CITY OF ALBUQUERQUE
PLANNING DEPARTMENT
May 25, 2011
DRB Comments

PROJECT # 10008826 APPLICATION # 11-70142

RE: Tract D-1A, Interstate Industrial Tract

Sketch Plat Tracts D1A-1, D1A-2 D1A-3, D1A-4 and D1A-5 Interstate Industrial Tract

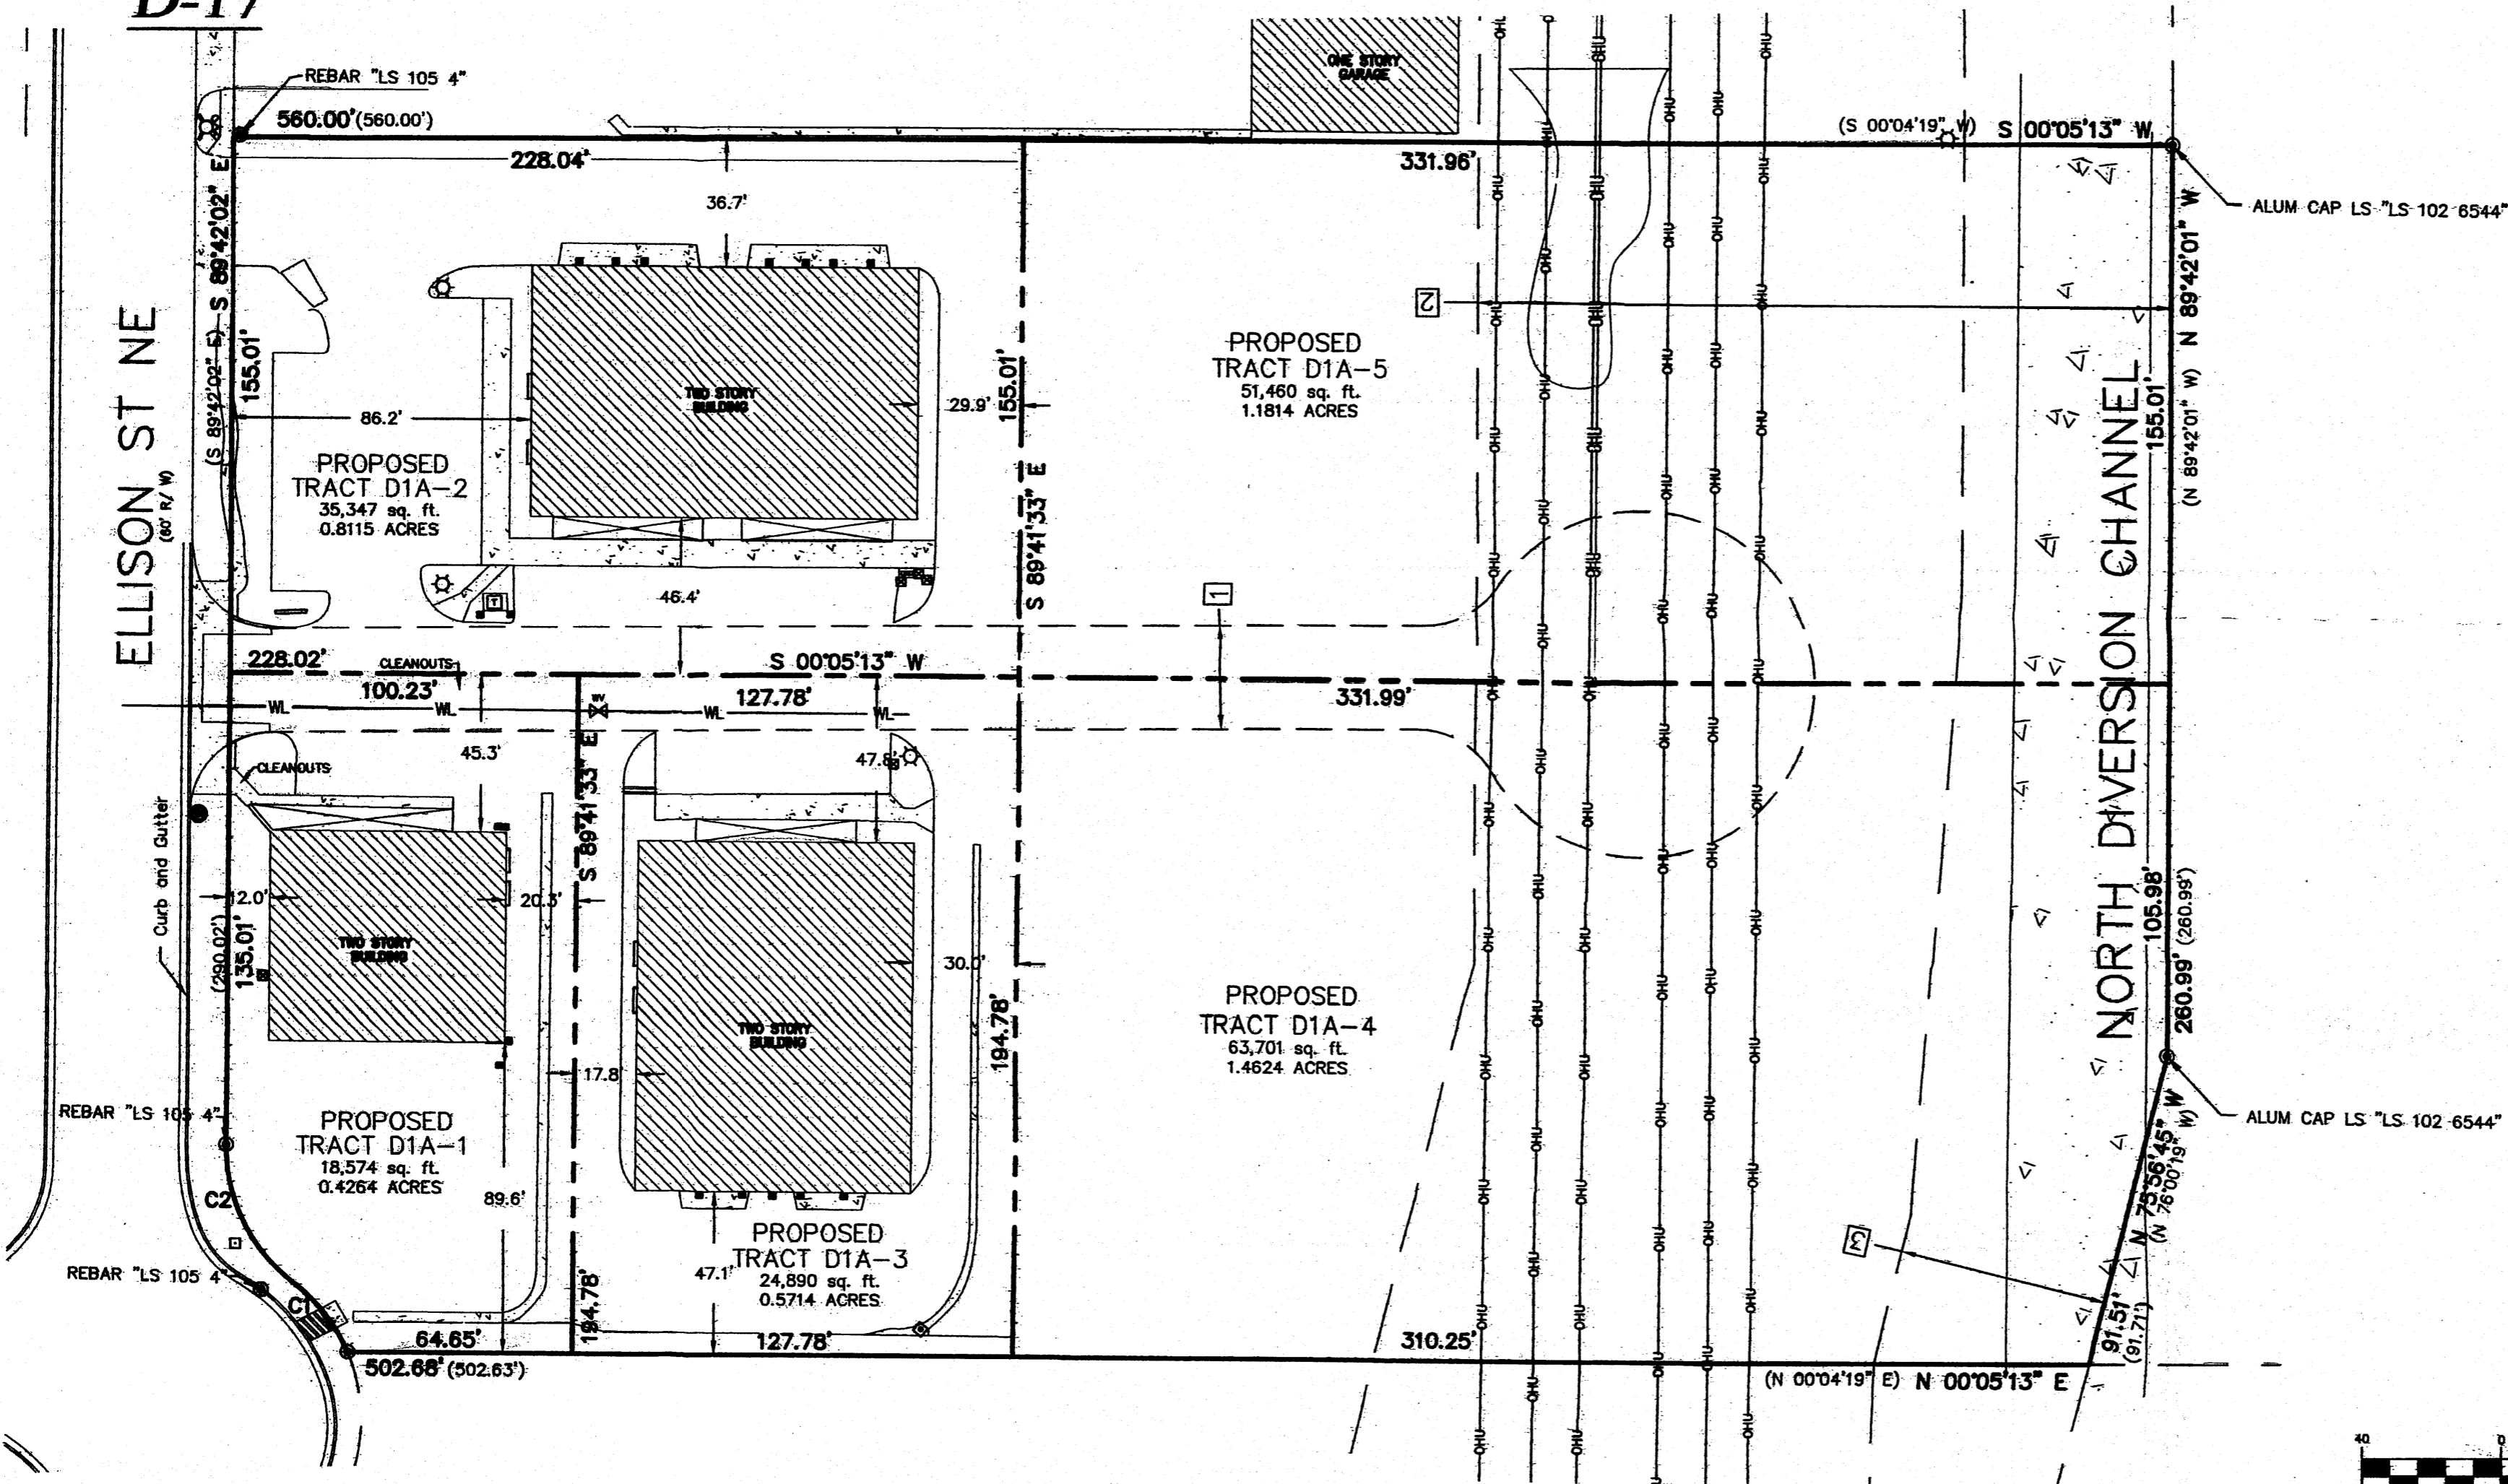
Compliance with Zoning Code requirements for parking and setbacks
(M-1 zone) must be demonstrated for each lot.
